Subject: Fwd: Fwd: Fwd: Ref: R/276/19/HH- Proposed rear extension at 9 Milton Avenue, Rustington, West Sussex BN16 2PP-resubmitting amended concerns.

Re: Concerns over Proposed rear extension to 9 Milton Avenue, Rustington West Sussex-BN16 2PP

Project: Proposed extension; 9 Milton Avenue, Rustington BN16 2PP	
Drawing: Plans and elevations as proposed	
For: Mr. & Mrs. Lamb	
Drawn: PKS	Date: November 2019
Scales: 1:50 1:100	No: 2523/01/02
To scale when printed on A3

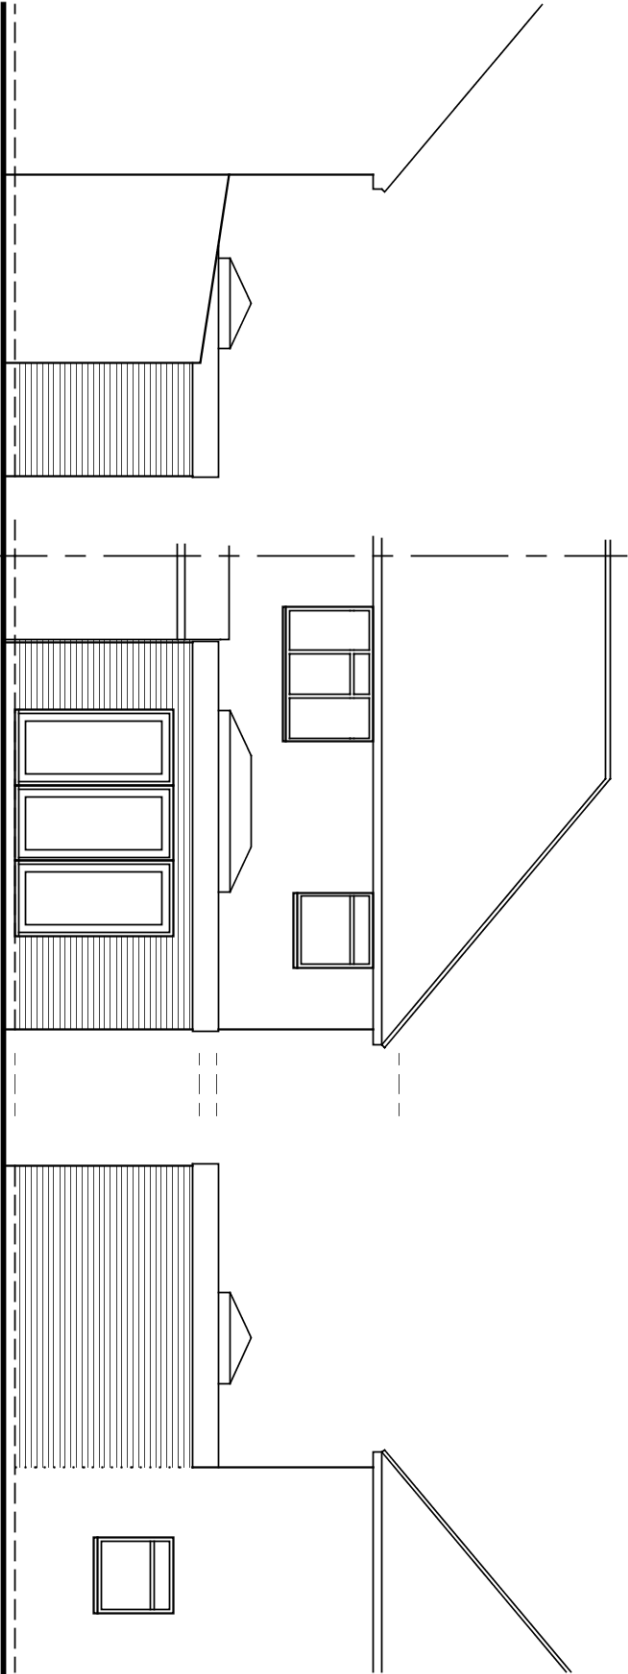
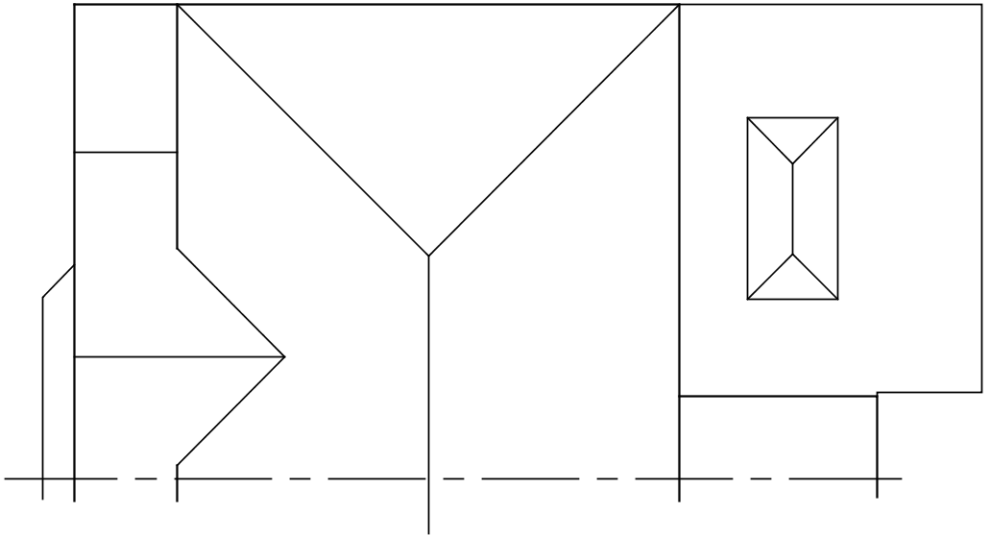
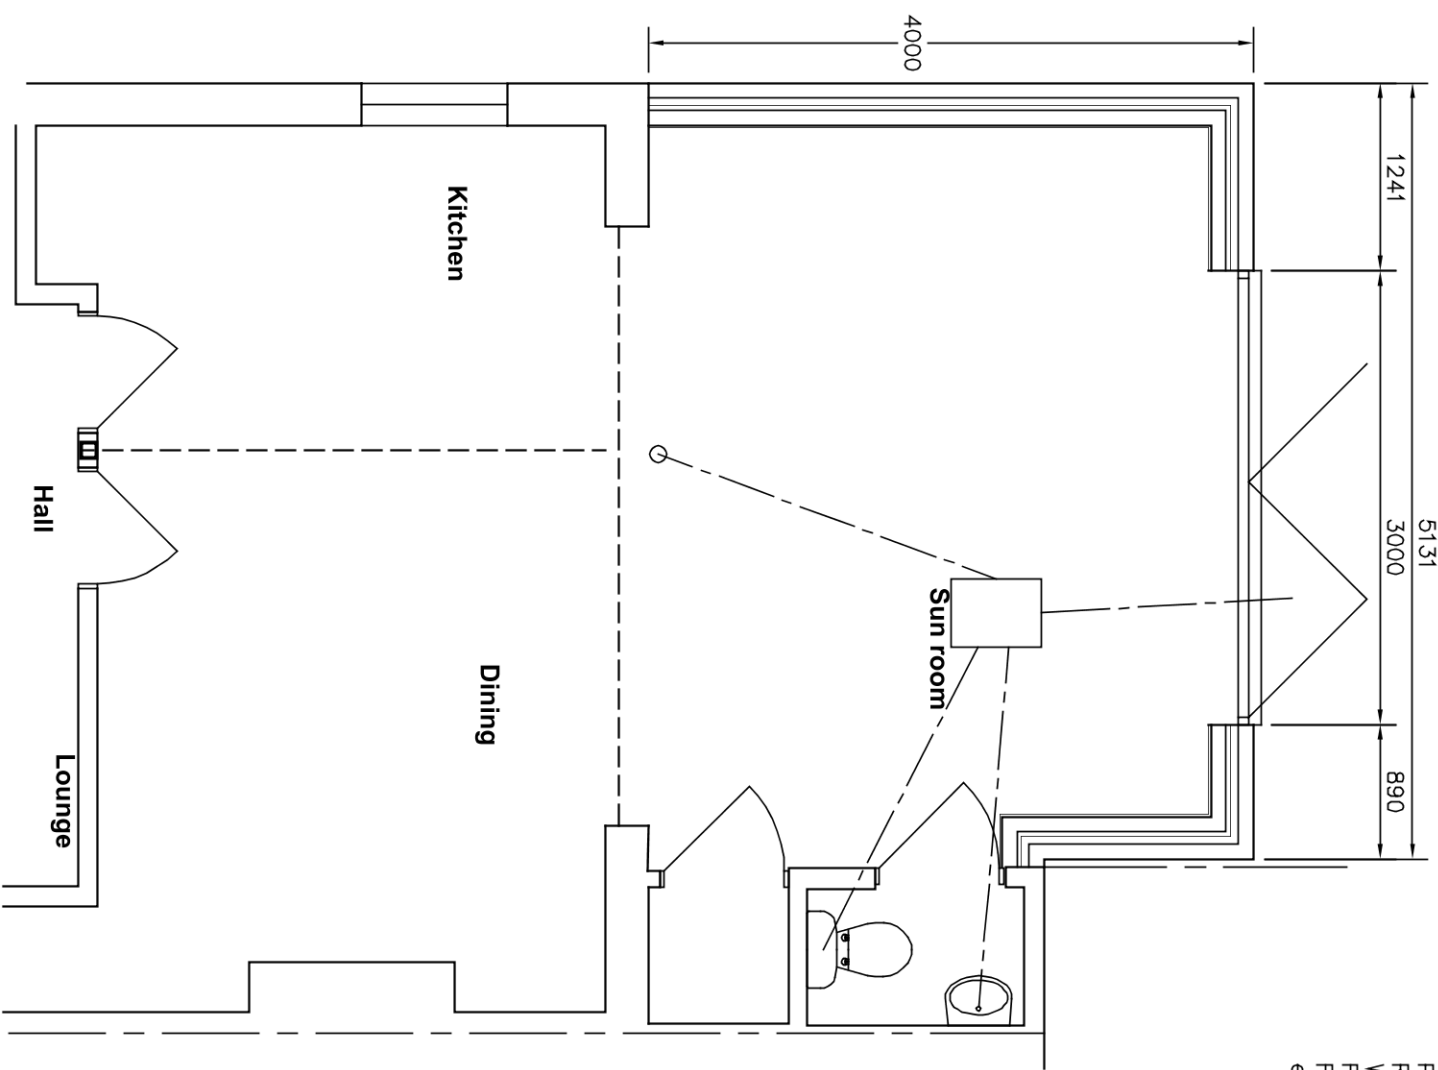
Is the wall of the extension replacing the existing boundary wall and fence? If so, the wall of the extension will intrude into my Mother's garden. We understand that the rear extension at number 9 Milton Avenue is 4 metres long. This is considerably longer than the existing conservatory.

Owing to the length of the extension, the wall of the extension will be almost parallel to a very old, beautiful tree in the garden of number 11. Have the neighbours considered the issue of tree roots and the other issues of a tree growing next to their home? Consent will not be given for this tree to be cut down.

This still needs clarification to us. Please consider issue of light, should the roof be pitched or higher than the existing conservatory roof the garden. This would compromise the amount of light into the garden of 11 Milton Ave. Similarly, should the wall of the extension become the boundary wall, the roof should not be protruding in any way into the garden of number 11.
